APPLICATION BY HIGHWAYS ENGLAND FOR AN ORDER GRANTING DEVELOPMENT CONSENT FOR THE A47 NORTH TUDDENHAM TO EASTON

Weston Longville Parish Council Reference:20028094

Written Representation: Wood Lane Junction: The case for review and an Issue Specific Hearing (ISH)

# PROPOSED WOOD LANE JUNCTION

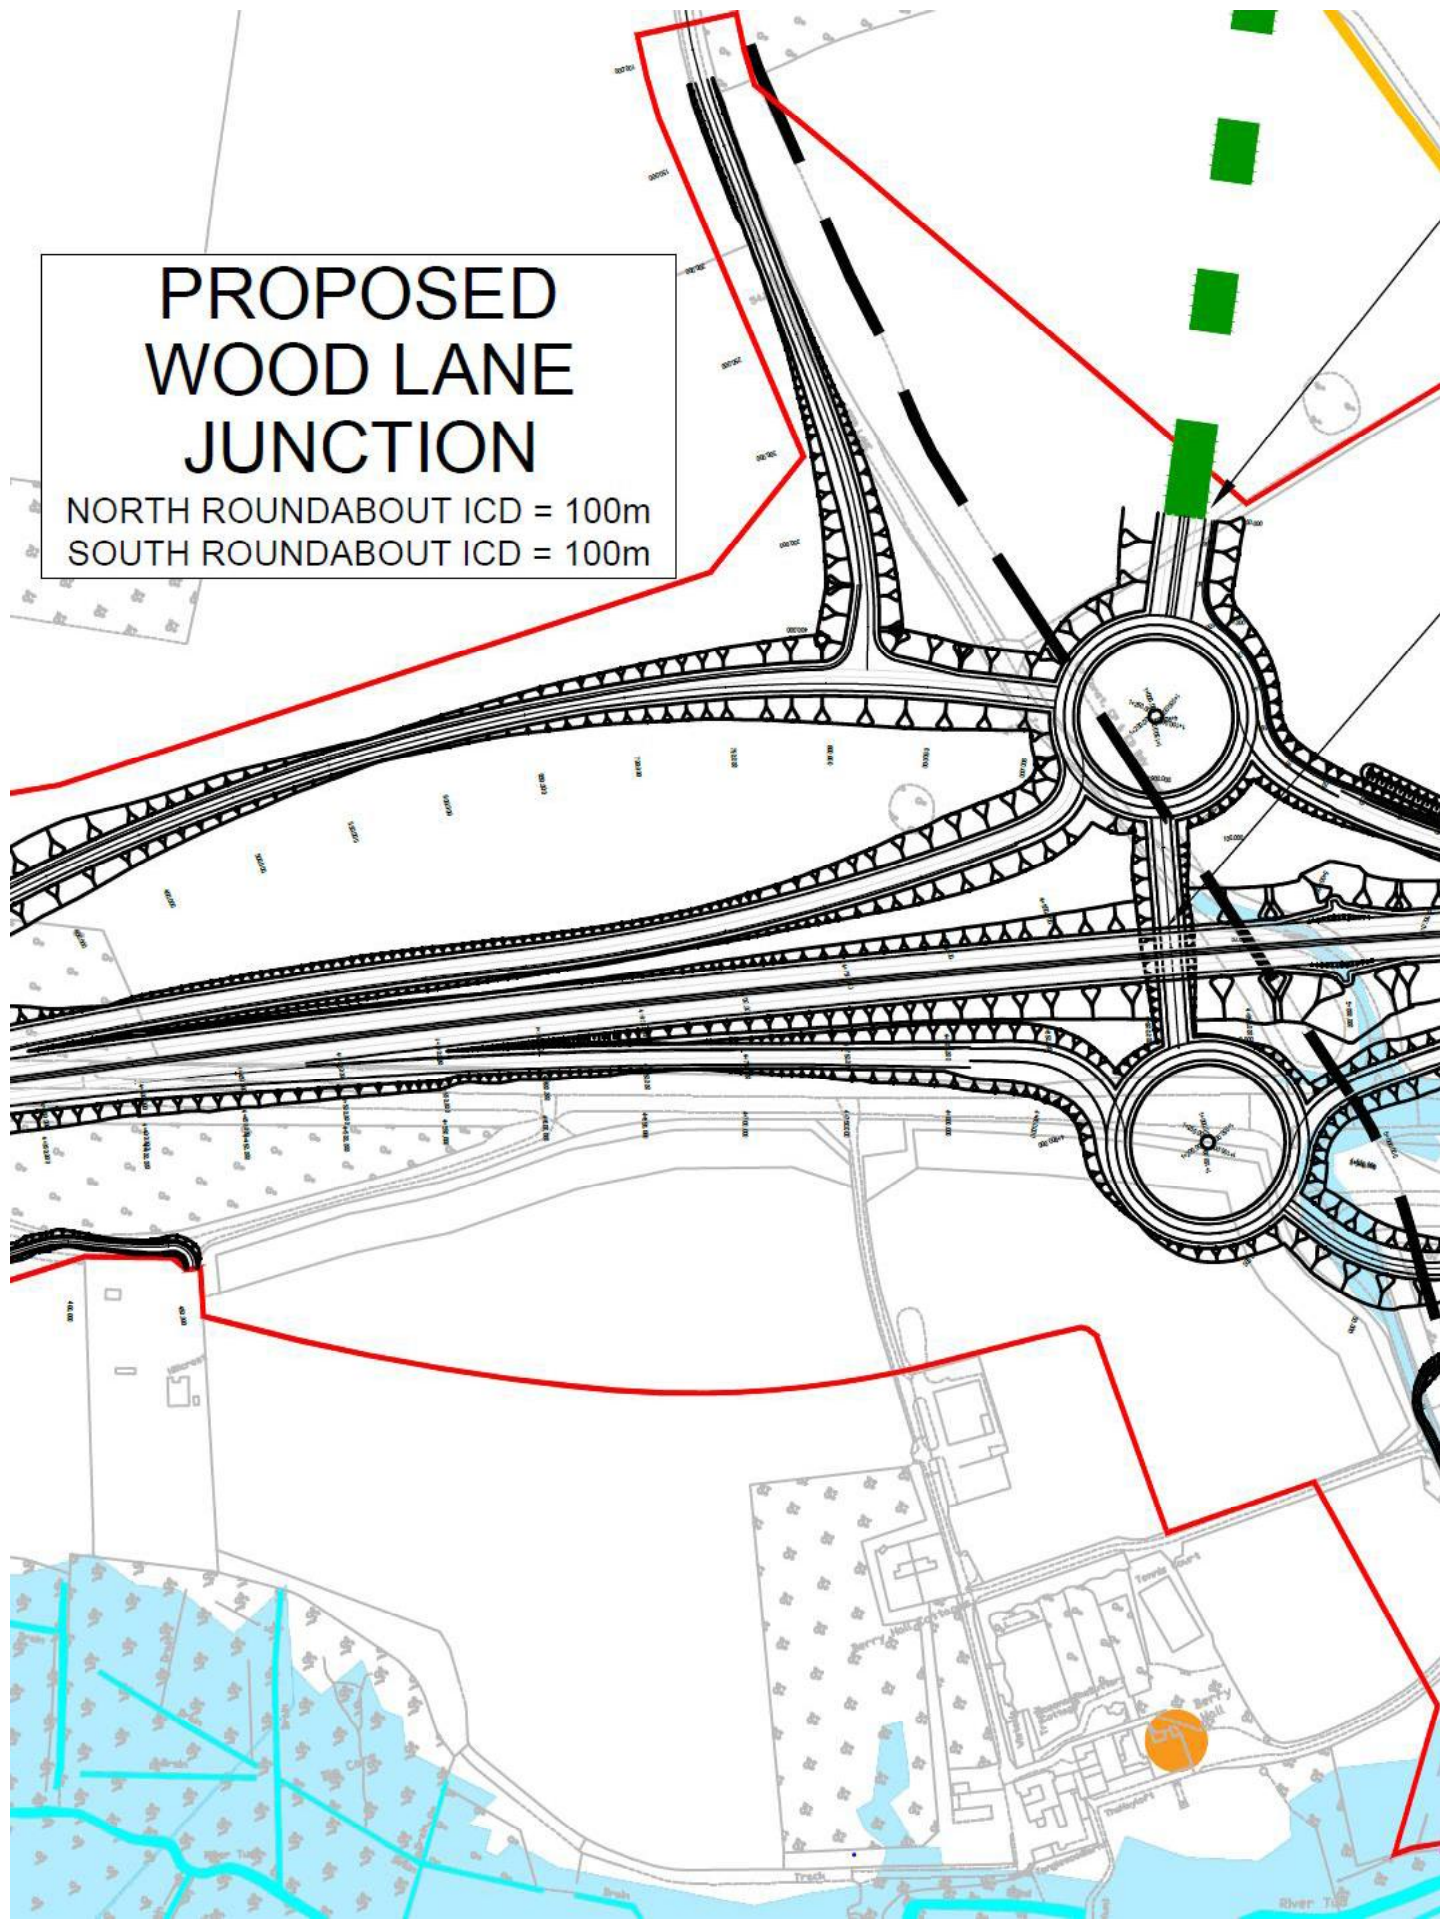
The parish councillors of Weston Longville are not road engineers, but we do know a lot about how our local roads are used and by whom. This has been a live issue for us for more than 20 years. Recognizing the significance of the Wood Lane junction we first proposed an interchange rather than a roundabout. The design, together with the email setting out the case, was submitted to HE in January 2020 and is set out in Appendix A. Also included is the response from James Powis (Project Manager).

None of the proposals made by WLPC were reflected in the March 2020 HE consultation, other than an offer of improved signage and making the access to the B1535 a spur off the northern roundabout at Wood Lane. When, at the consultation event in Hockering, WLPC queried the decision to reject an interchange we were told the predicted traffic volumes did not justify the cost. WLPC went back to the drawing board. The proposal was amended to take account of HE's reservations about an interchange. WLPC's objective is to separate the

B1535 from any direct access to the roundabout at the Wood Lane junction and thus make the Norwich Western Link the default route. The design and justification are attached as Appendix B. Again, nothing in the subsequent DCO application reflected our concerns or our submission and WLPC have had no direct contact with HE since January 2021.

WLPC's objective of separating the B1535 from the roundabout could be achieved by moving the location of the roundabout and running the B1535 under the new road to connect to the old A47. In rejecting options which increased the number of underpasses on the grounds of cost HE has ended up with an over engineered, sprawling design more appropriate to an urban rather than a rural setting.
